CITY OF ALBUQUERQUE

December 3, 2019

Re: Tiny Homes
105 Texas St SE Albuquerque, NM 87108
Traffic Circulation Layout
Engineer's/Architect's Stamp 10-30-19 (K19D138)

TITLE
**TRAFFIC CONTROL LAYOUT
PROPOSED CONDITIONS**

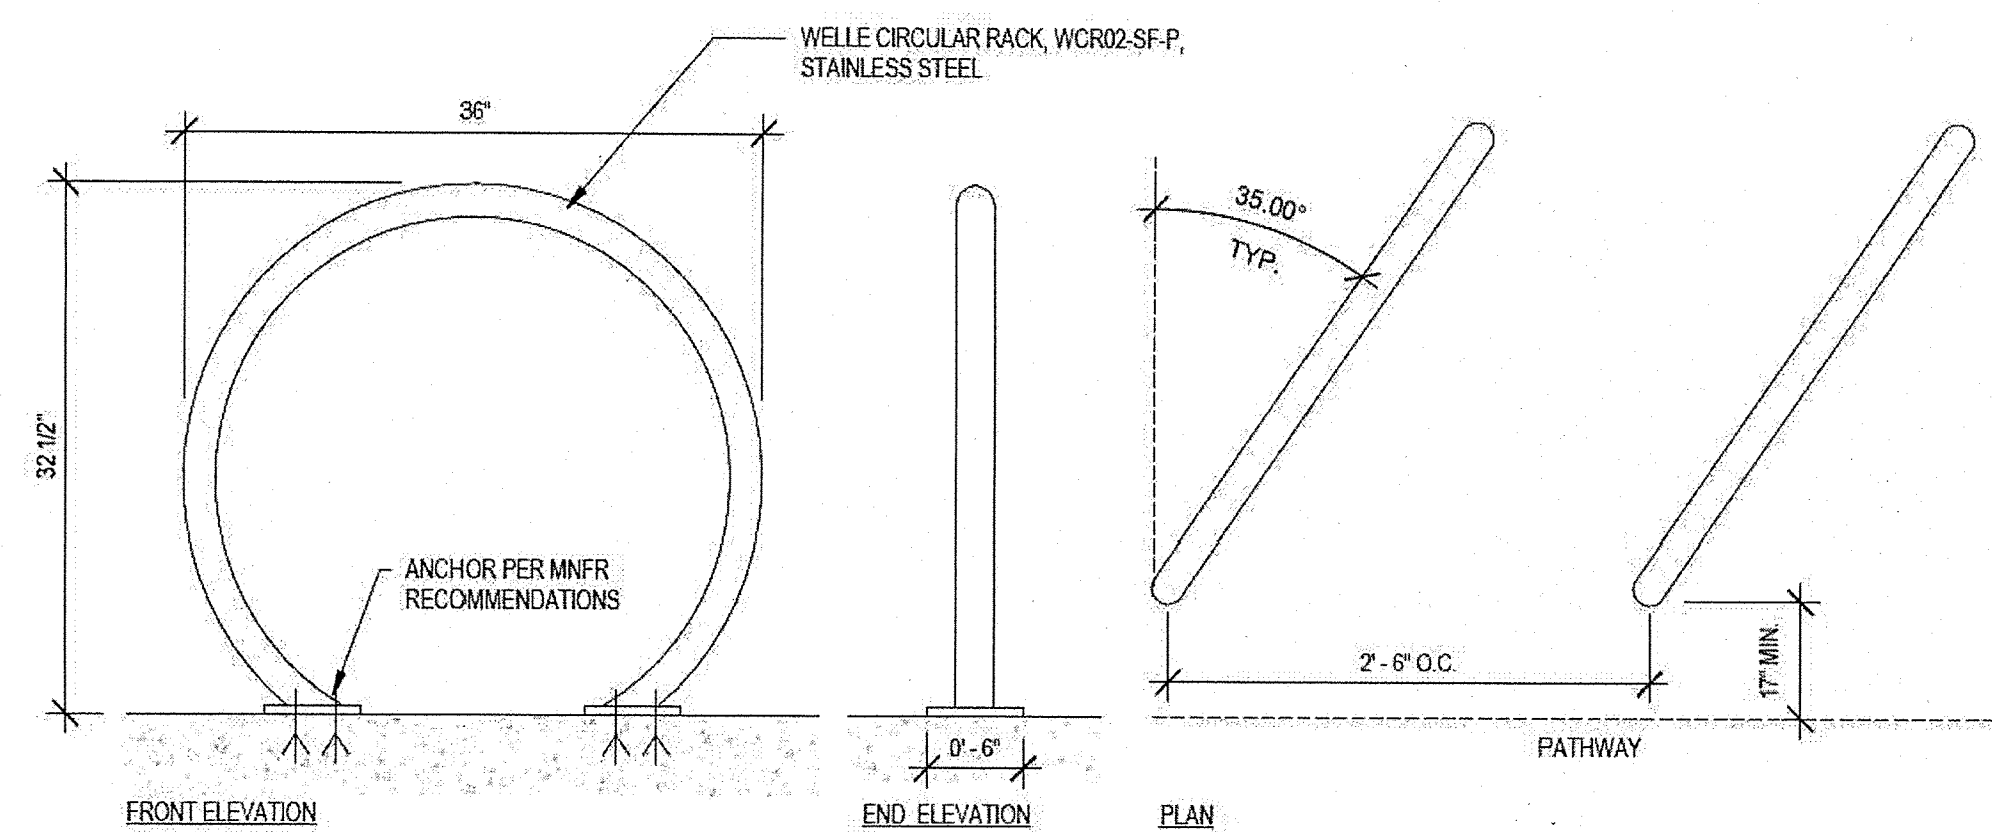
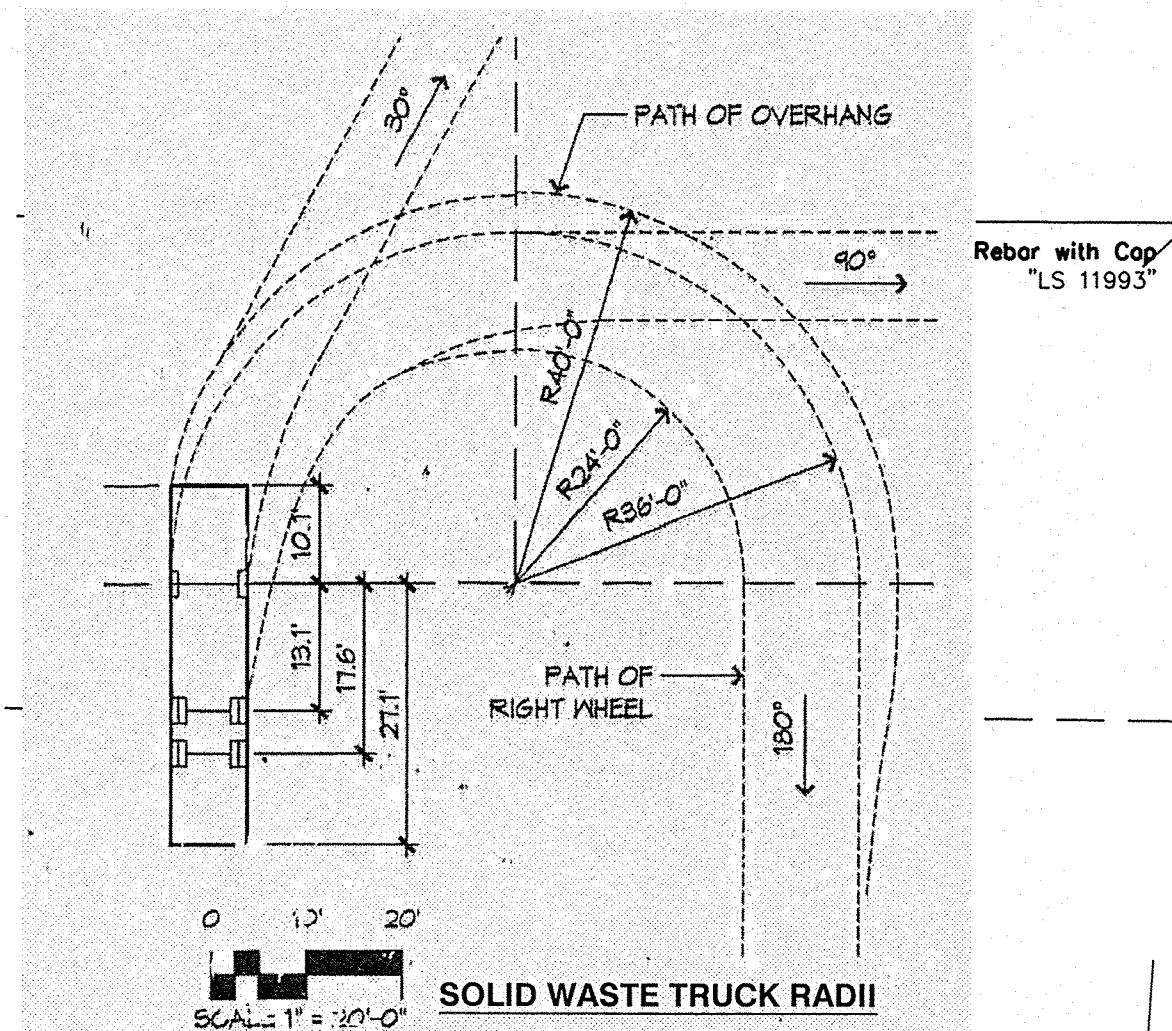
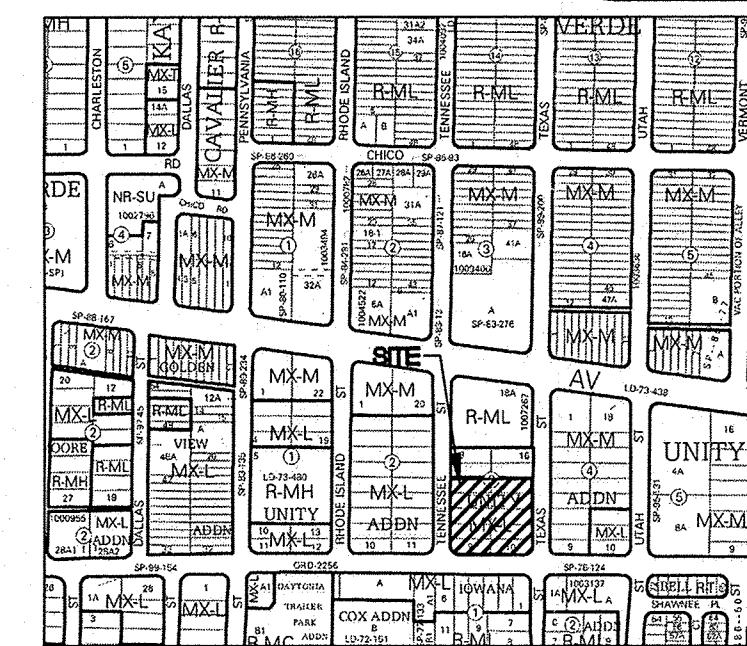
1. Please list the width and length for all existing and proposed parking spaces. Some dimensions are not shown.
2. The ADA accessible parking sign must have the required language per 66-7-352.4C NMSA 1978 **"Violators Are Subject to a Fine and/or Towing."** Please call out detail and location of signs.

3. The ADA access aisles shall have the words **"NO PARKING"** in capital letters, each of which shall be at least one foot high and at least two inches wide, placed at the rear of the parking space so as to be close to where an adjacent vehicle's rear tire would be placed. (66-1-4.1.B NMSA 1978)

4. Motorcycle parking spaces shall be designated by its own conspicuously posted upright sign, either free-standing or wall mounted per the zoning code.

5. All bicycle racks shall be designed according to the following guidelines:
 - a. The rack shall be a minimum 30 inches tall and 18 inches wide.
 - b. The bicycle frame shall be supported horizontally at two or more places. Comb/toaster racks are not allowed.

- c. The rack shall be designed to support the bicycle in an upright position. See the IDO for additional information.
 - d. The rack allows varying bicycle frame sizes and styles to be attached.

- e. The user is not required to lift the bicycle onto the bicycle rack.
 - f. Each bicycle parking space is accessible without moving another bicycle.

6. Bicycle racks shall be sturdy and anchored to a concrete pad.
7. A 1-foot clear zone around the bicycle parking stall shall be provided.
8. Bicycle parking spaces shall be at least 6 feet long and 2 feet wide.

9. Show all drive aisle widths. Some dimensions are not shown.
10. Refuse container seems to be very close to the parking space in the existing AIC parking lot. Please show distance.
11. Refuse vehicle maneuvering shall be contained on-site. The refuse vehicle shall not back into the public right of way.; provide a copy of refuse approval.
12. Show the clear sight triangle and add the following note to the plan: "Landscaping and signage will not interfere with clear sight requirements. Therefore, signs, walls, trees, and shrubbery between 3 and 8 feet tall (as measured from the gutter pan) will not be acceptable in the clear sight triangle.
13. Add a note stating "All broken or cracked sidewalk must be replaced with sidewalk and curb & gutter." A build note must be provided referring to the appropriate City Standard drawing.
